Our ref: Griffith Battery Energy Storage System (SSD-85372970)

Subject: Request for Additional Information

Drawing Title		
GRIFFITH BESS HEAVY VEHICLE SITE ACCESS SWEPT PATH ANALYSIS		
Designed DA	Approved VG	Metway Ref NA
Project Number 250170	Drawing Number SPA101	Revision A

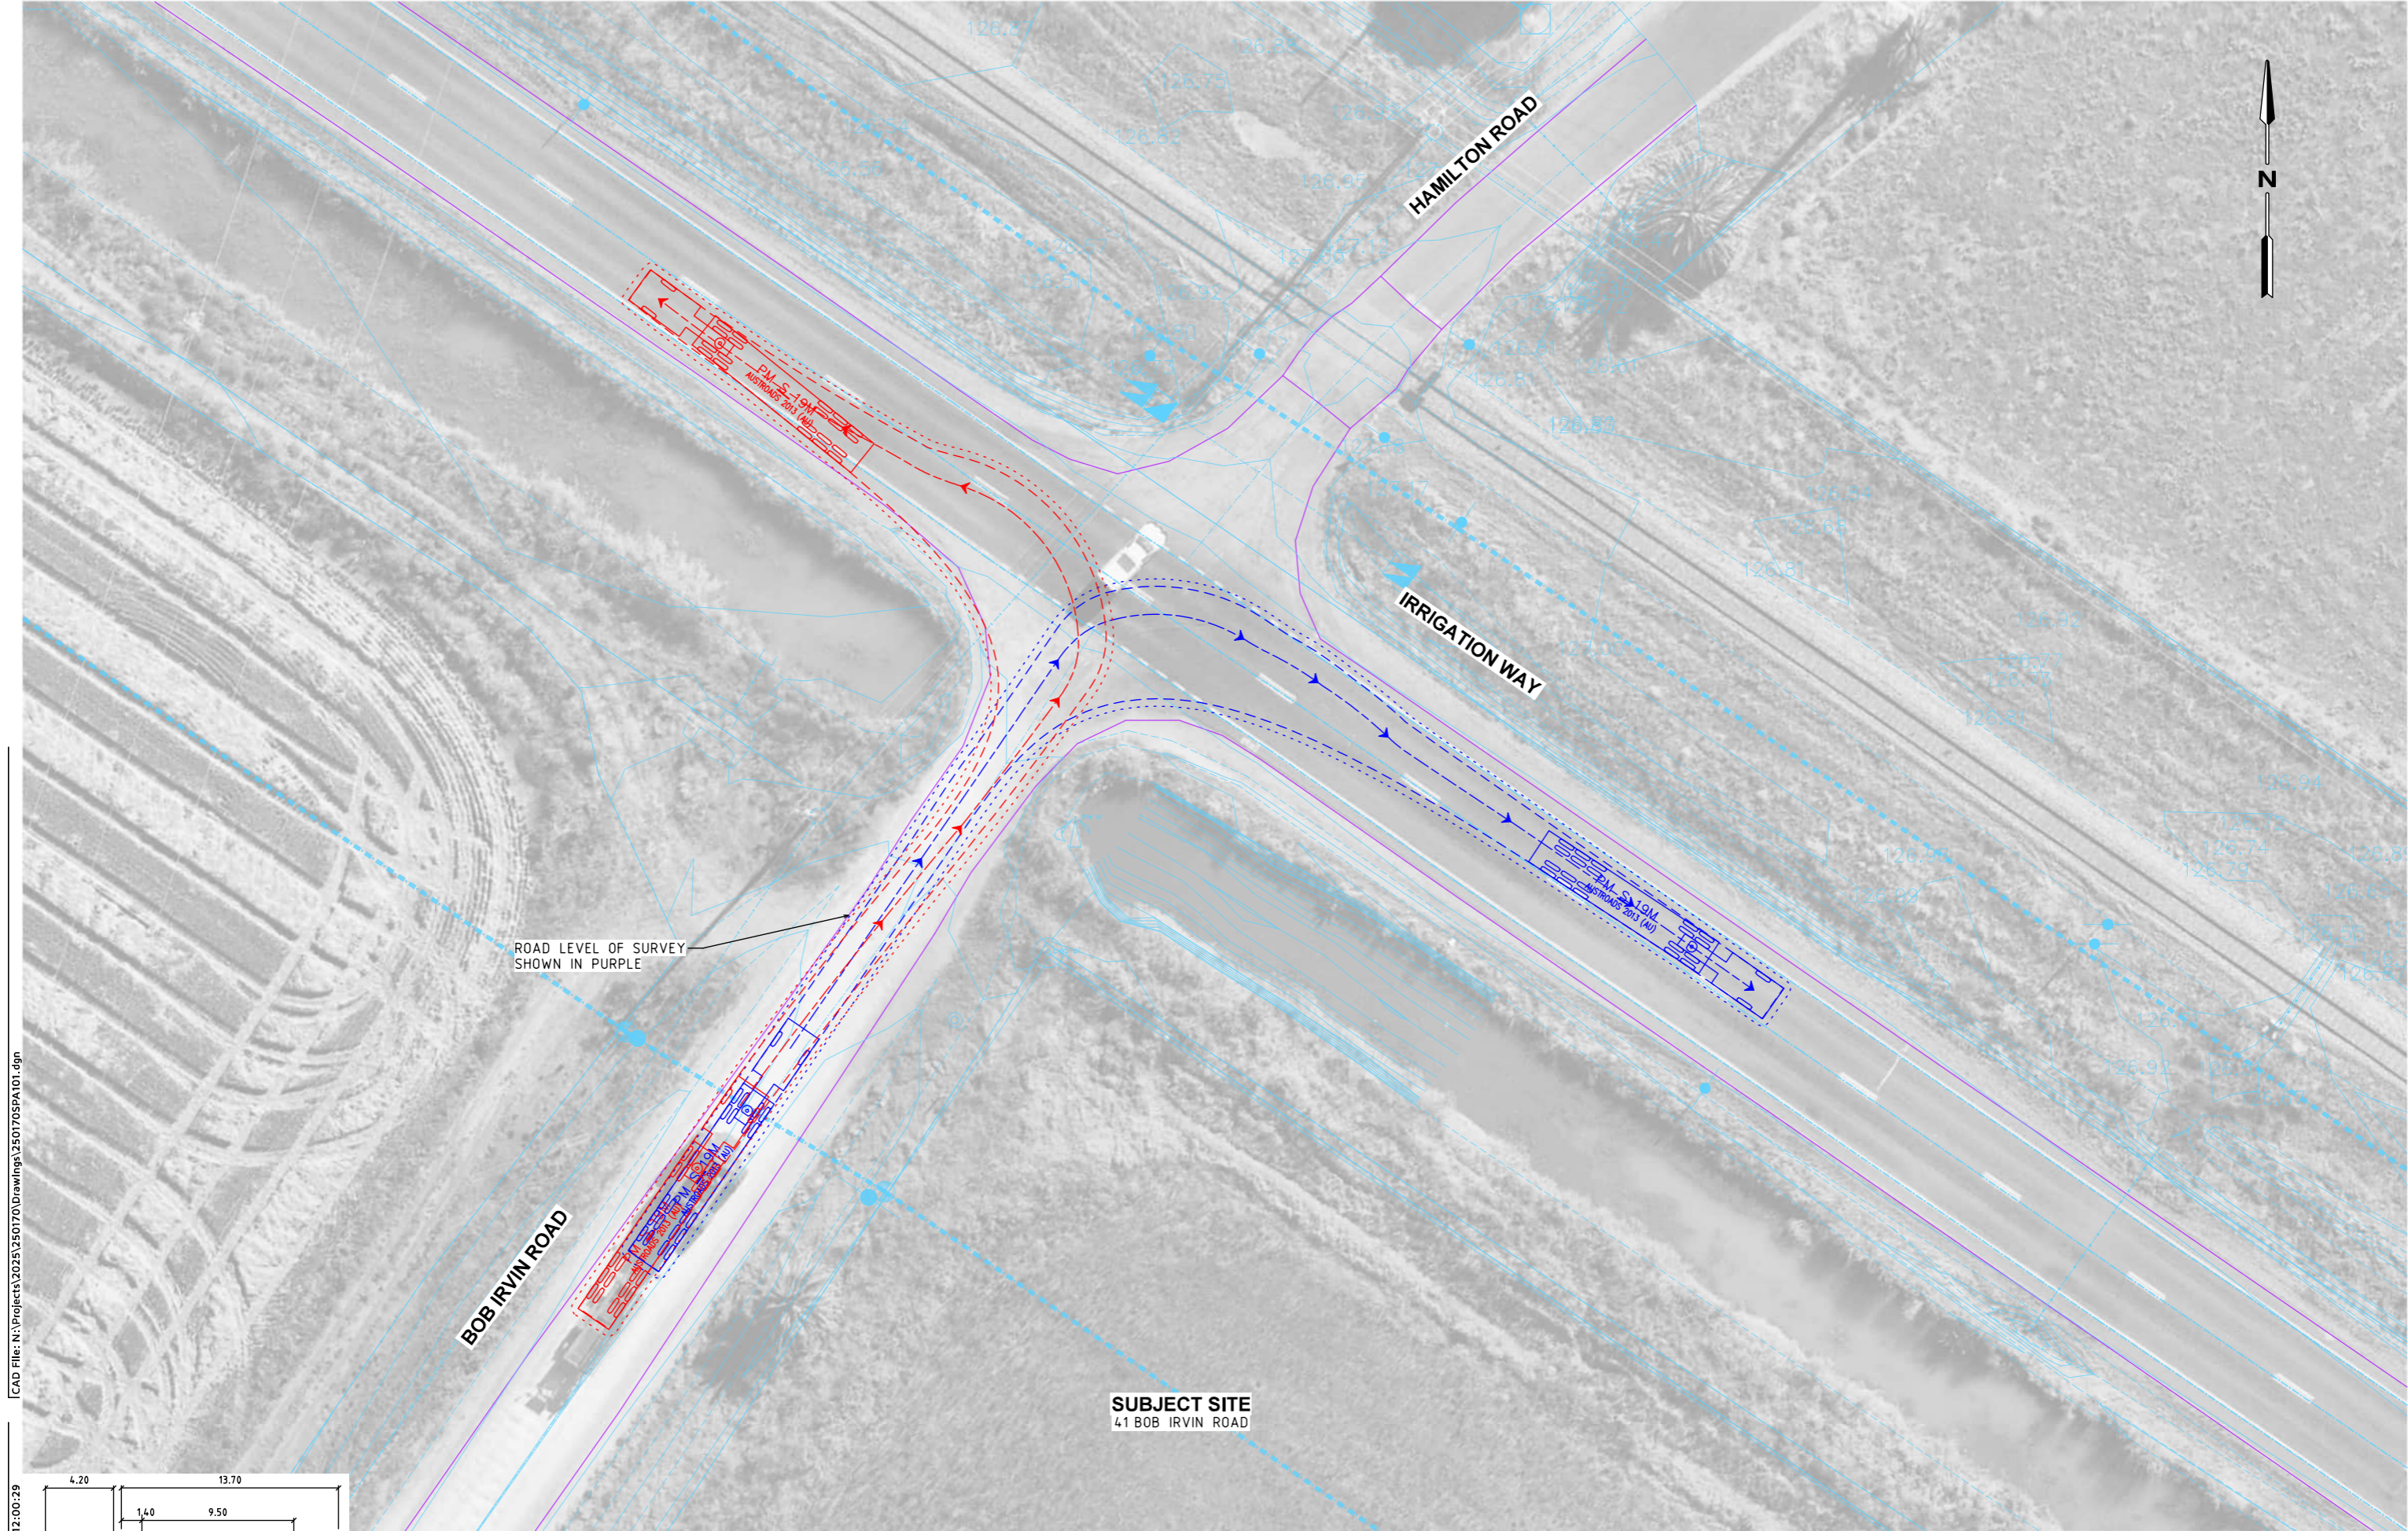
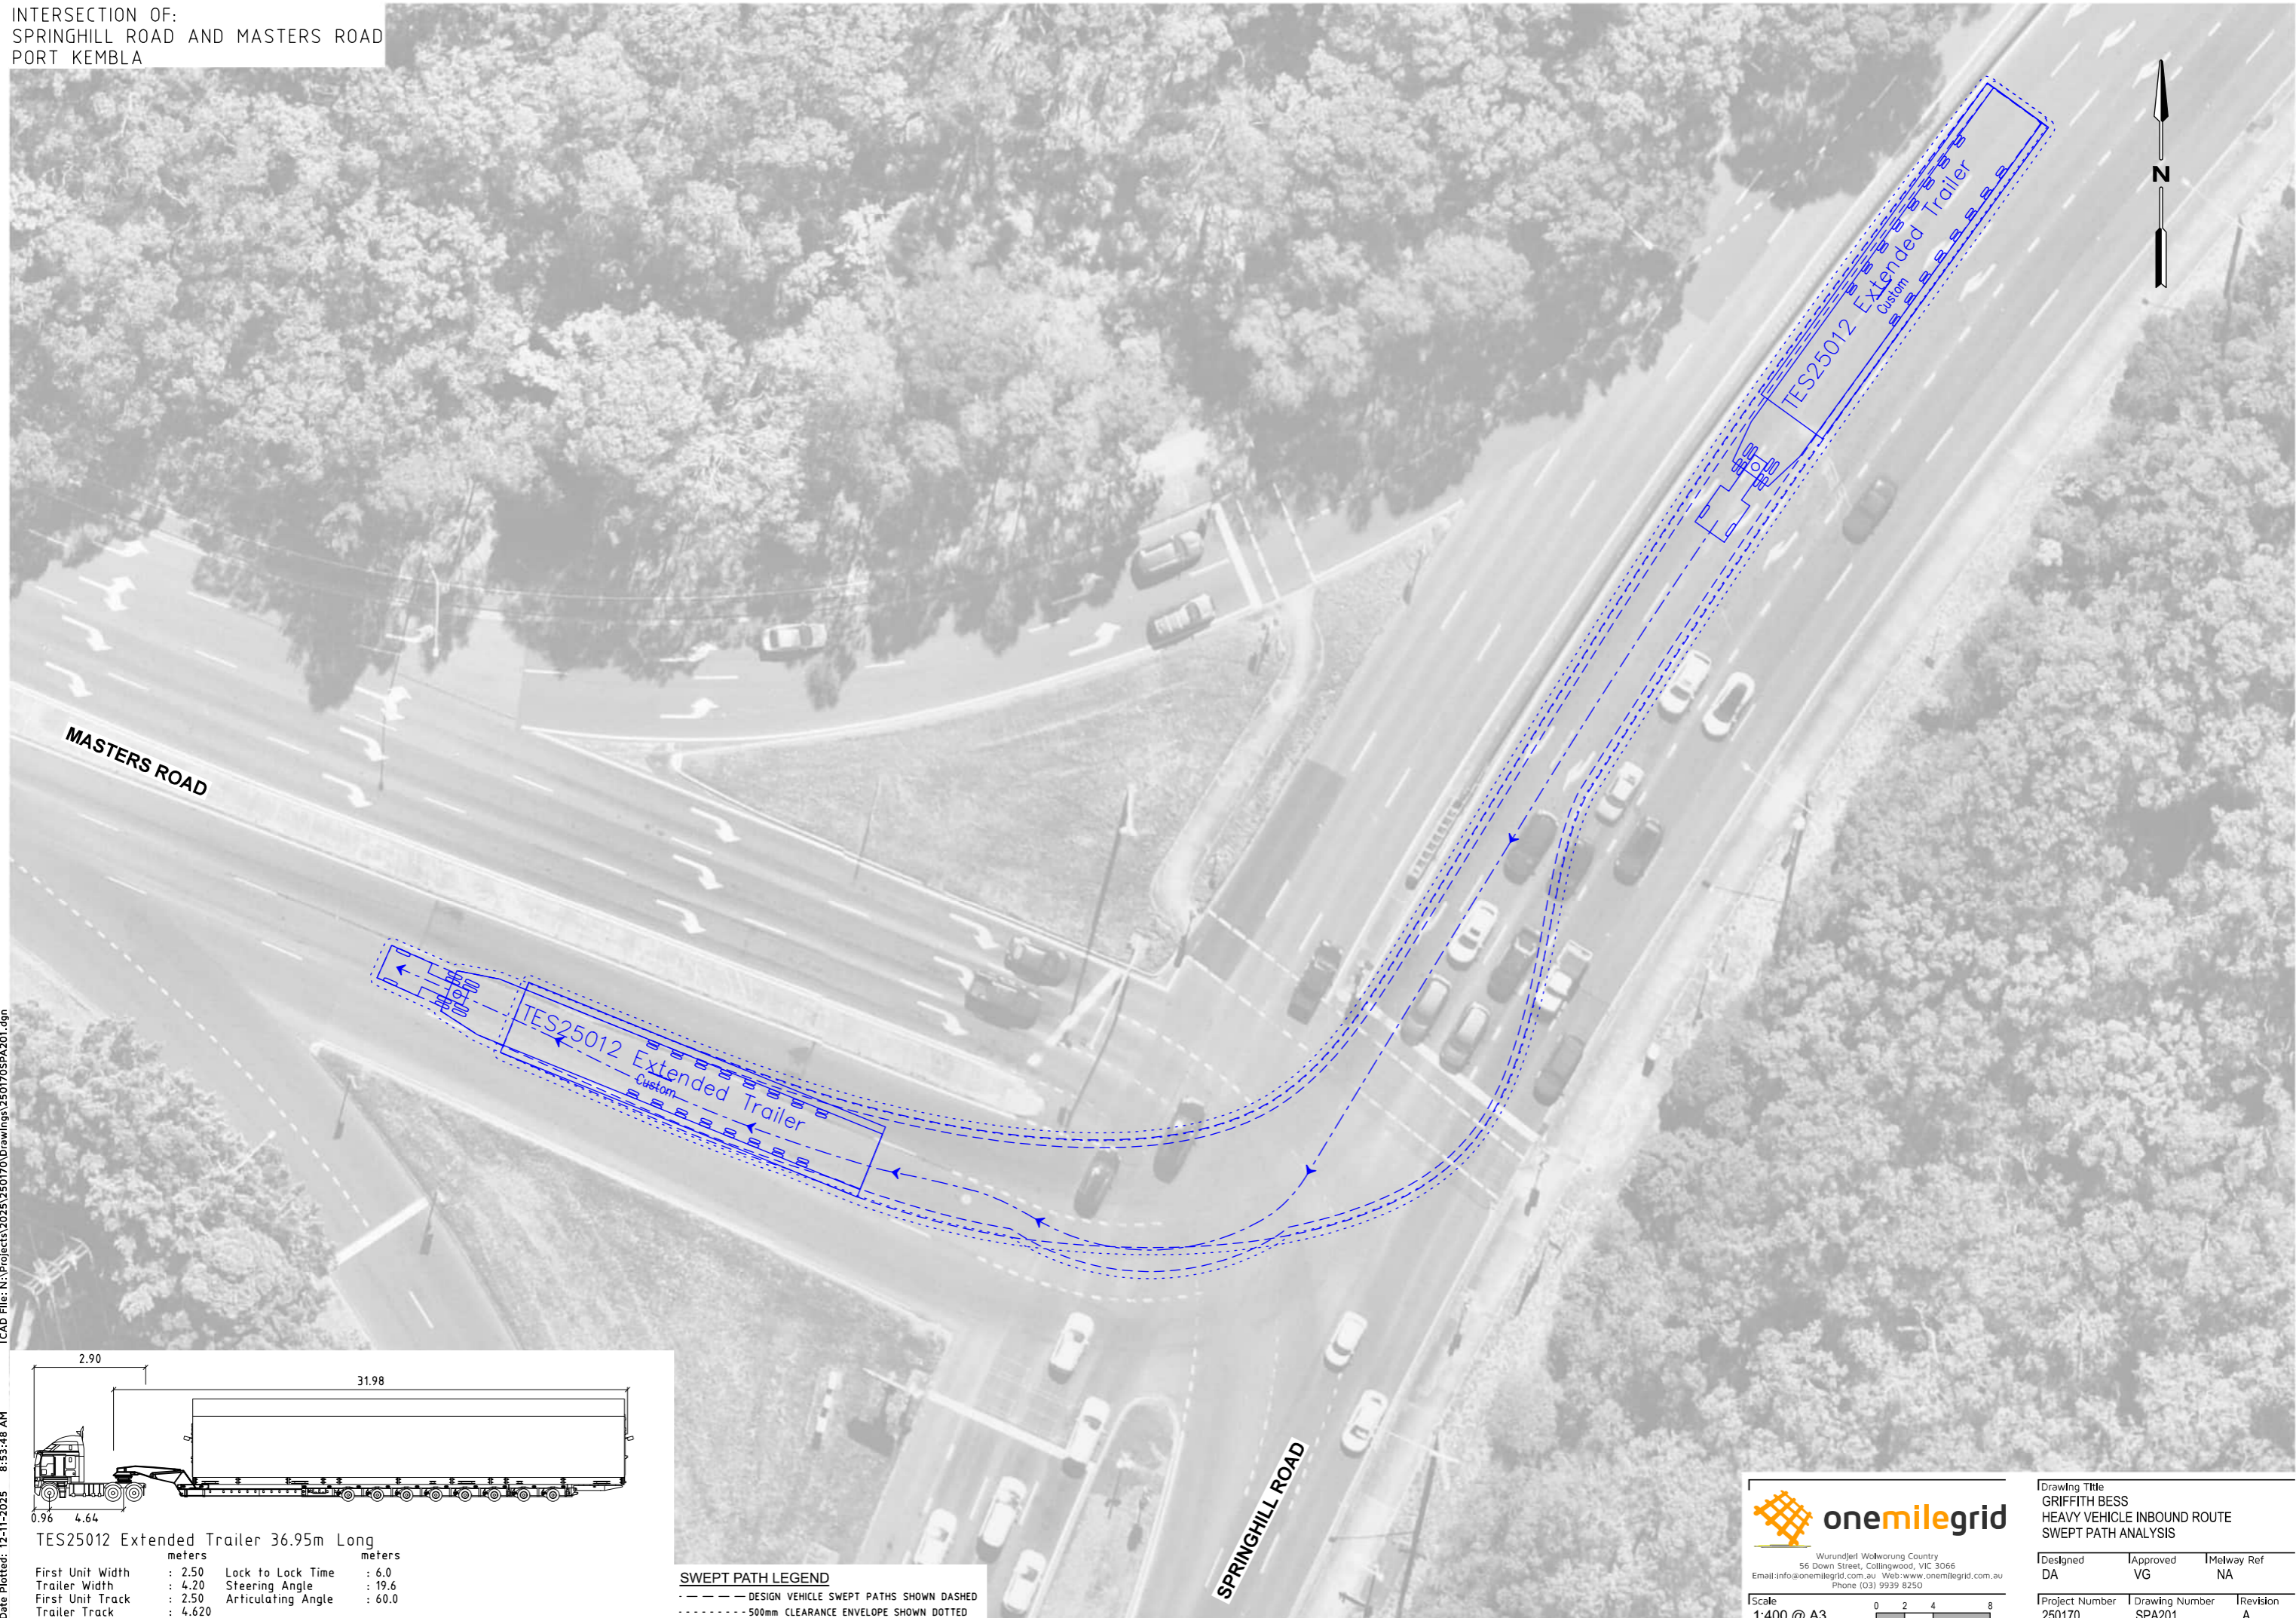
- further detail on transport and traffic matters, including:
 - o on the load capacity and dimensions (including vertical geometry) of the culverts proposed to be traversed for the heavy vehicle requiring escort and heavy vehicle haulage routes;
 - o update the swept path diagrams to identify the proposed roadworks to medians, aprons and other road structures; and
 - o clarification on the transmission line crossing Irrigation Way and on pre-construction minor works;
- further detail on the project area and site design, including on the total development footprint (in hectares), consideration of construction and equipment laydown areas for constructability, and provision of high level concept designs for the three proposed site access points; and
- provision of landowners consent for all areas with road works proposed along the haulage route.
